## ARBORIST RESPONSE TO CITY REVIEW COMMENTS

REFERENCE: Arborist Response to City Review Comments RE: SUB22-009 (Cui Preliminary Short Subdivision)

SITE ADDRESS: 4833 90<sup>th</sup> Ave SE, Mercer Island, WA

DATE: 1/7/2024

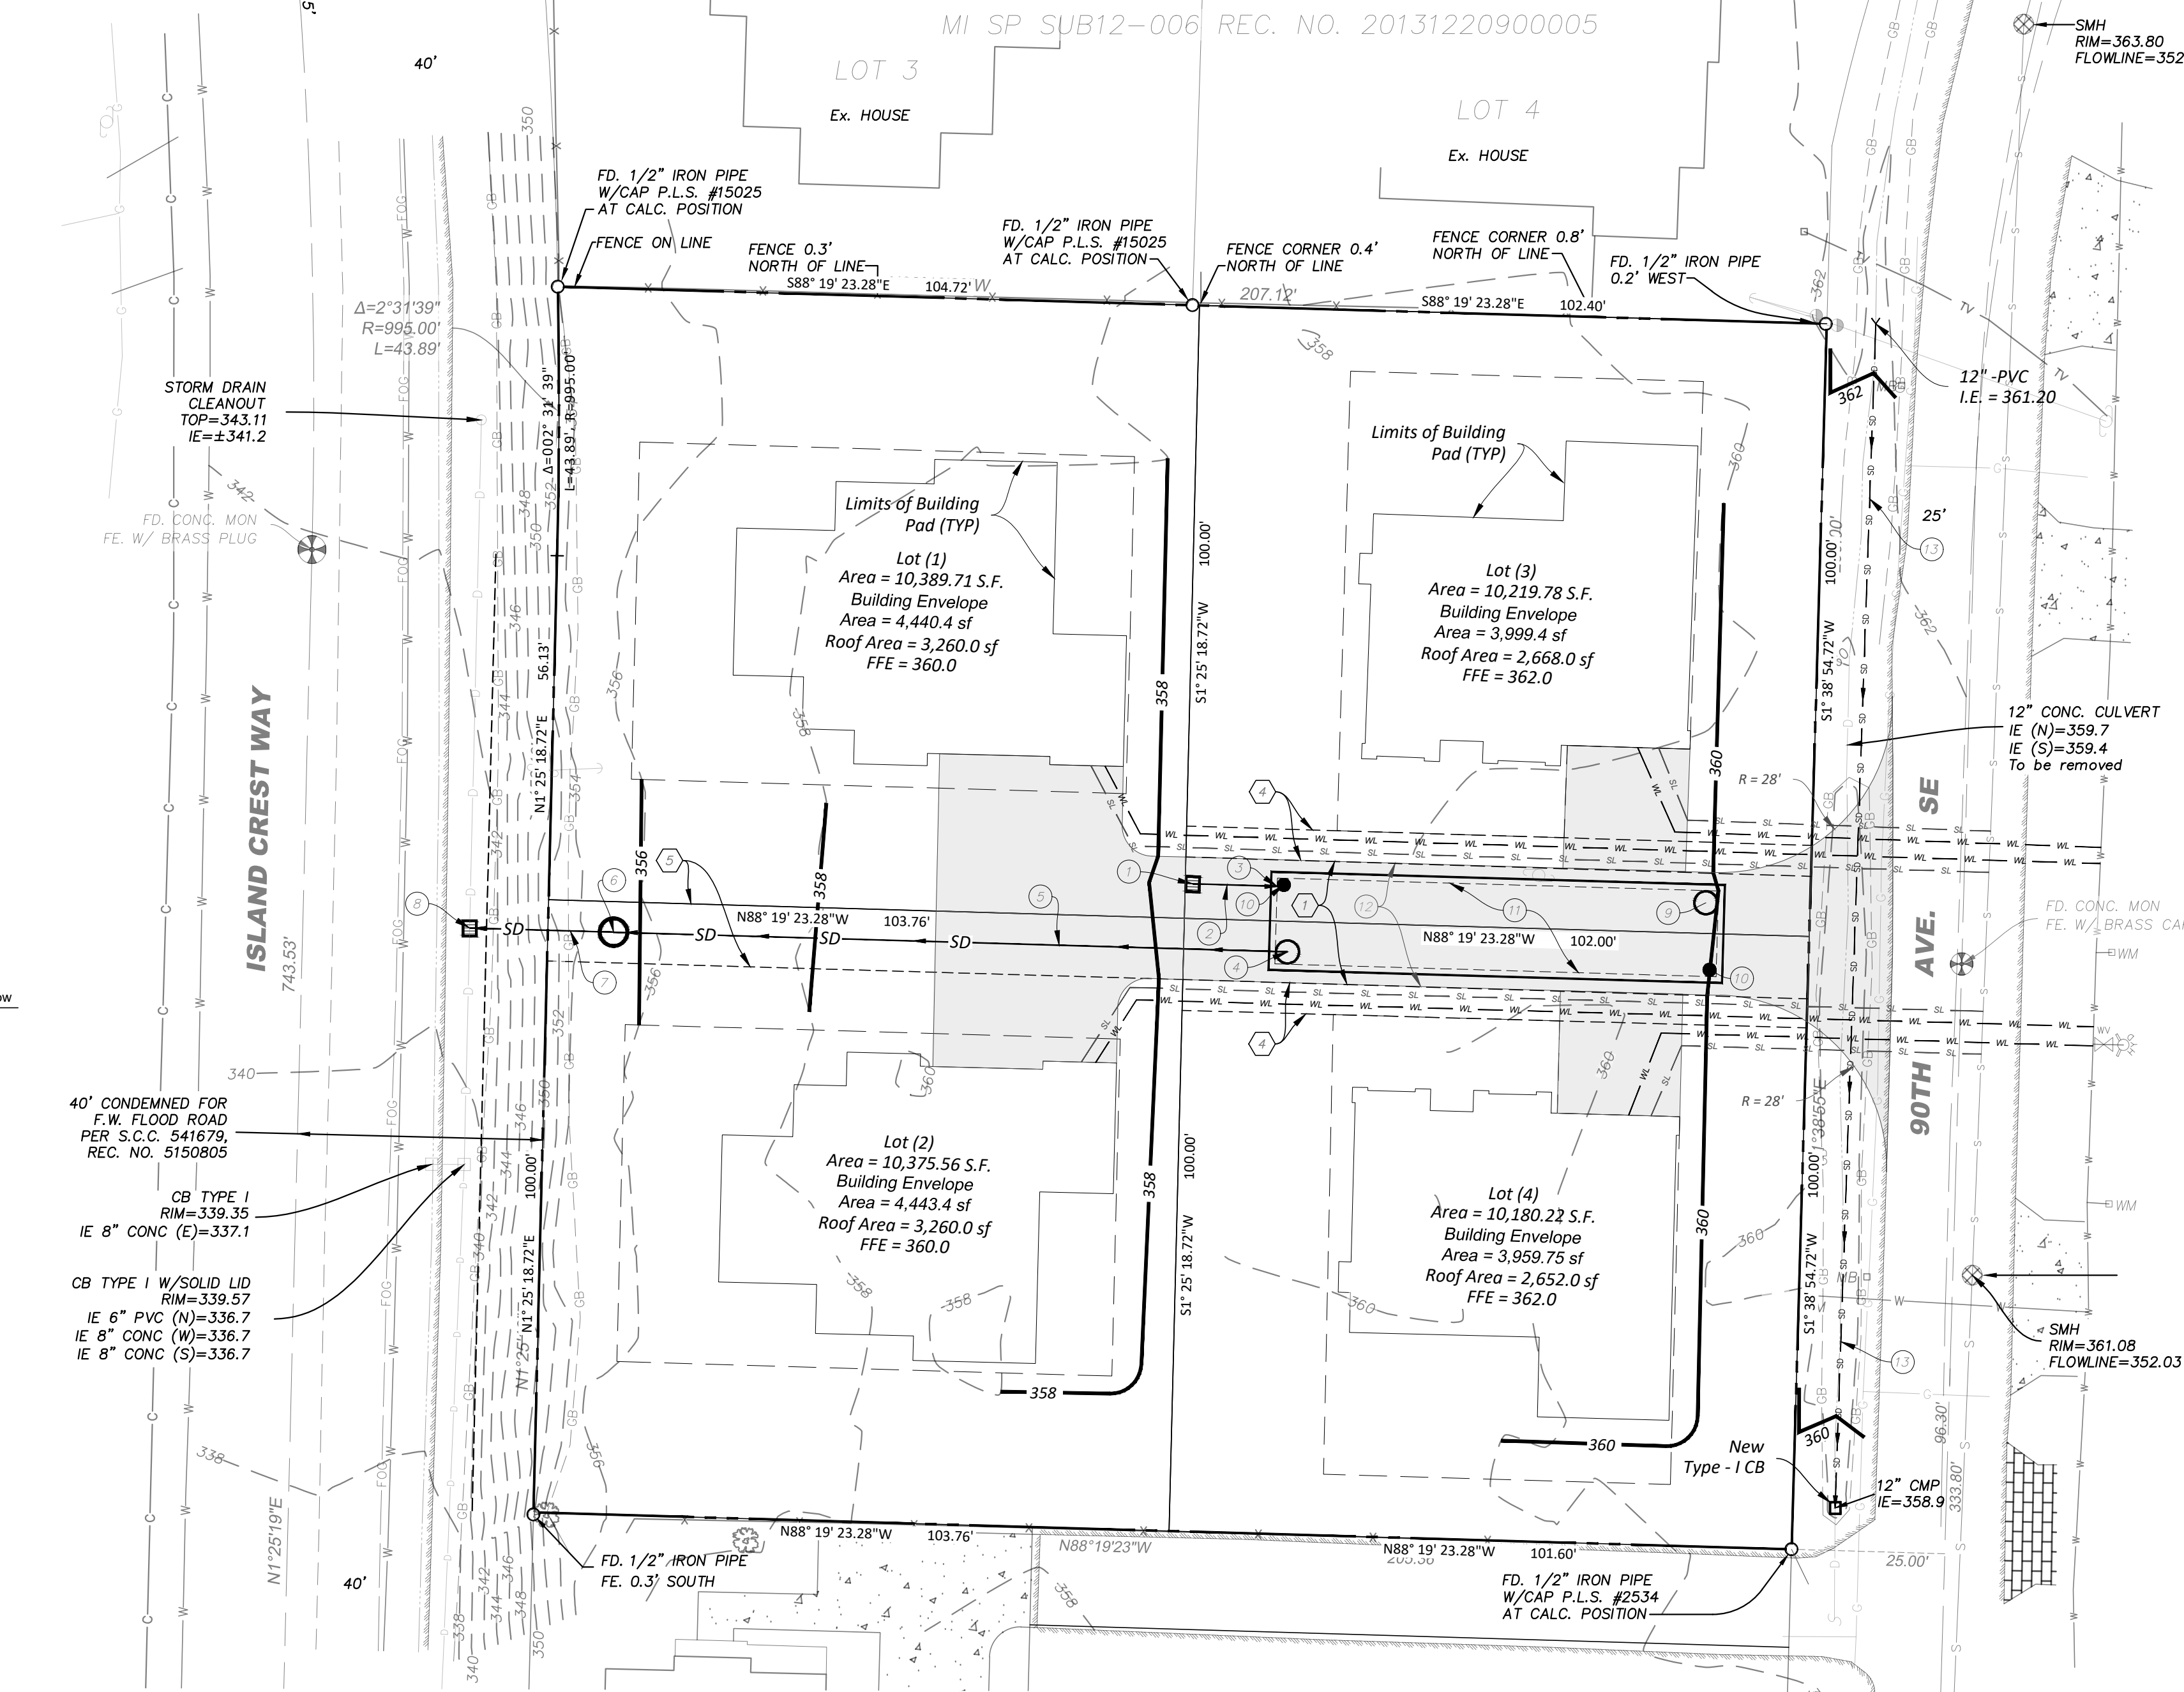
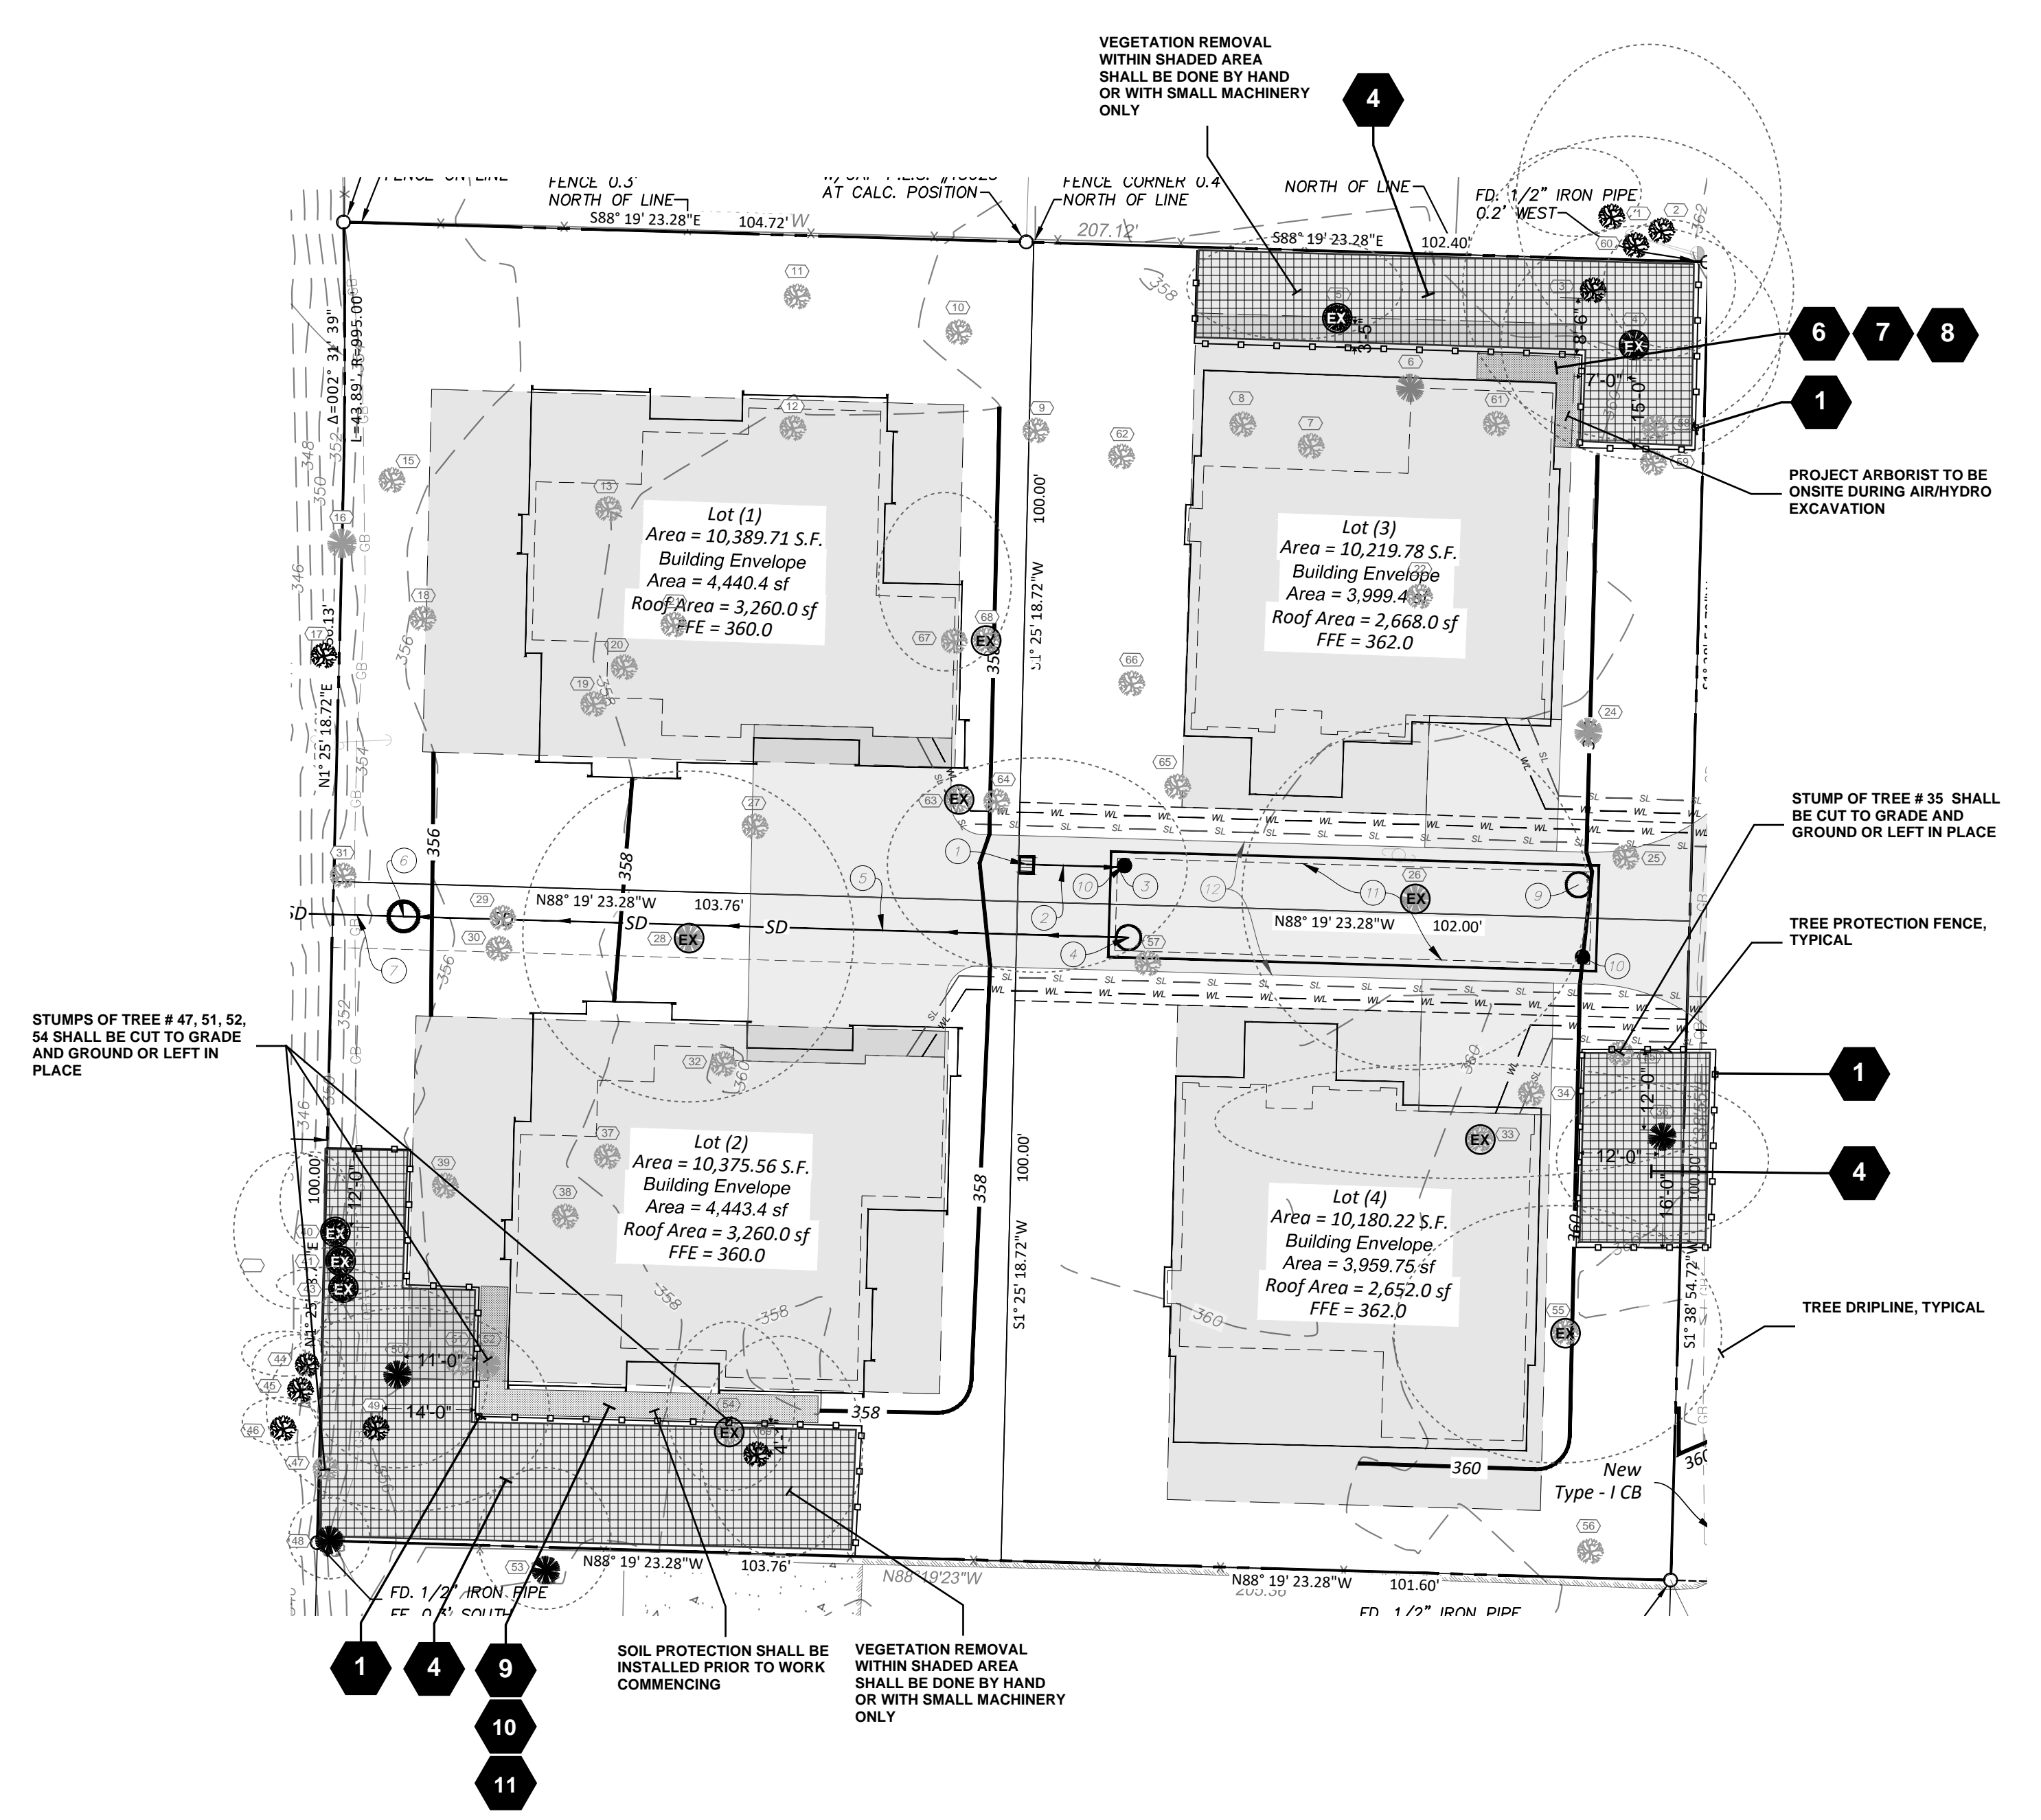
**3. Trees 7, 57, 61, 62, 65 are listed on the tree inventory worksheet as large regulated trees but are non-regulated since they are below 10 inches in diameter and do not become exceptional at that size. This will impact your percentage of trees to be retained. These trees are not required to be replaced since they are non-regulated.**

Arborist response: These five trees have been removed from the tree table and sheet TR-01. With these 5 trees removed, overall tree retention for this project is now at 32.7-percent. See the provided updated Tree Calculation Worksheet.
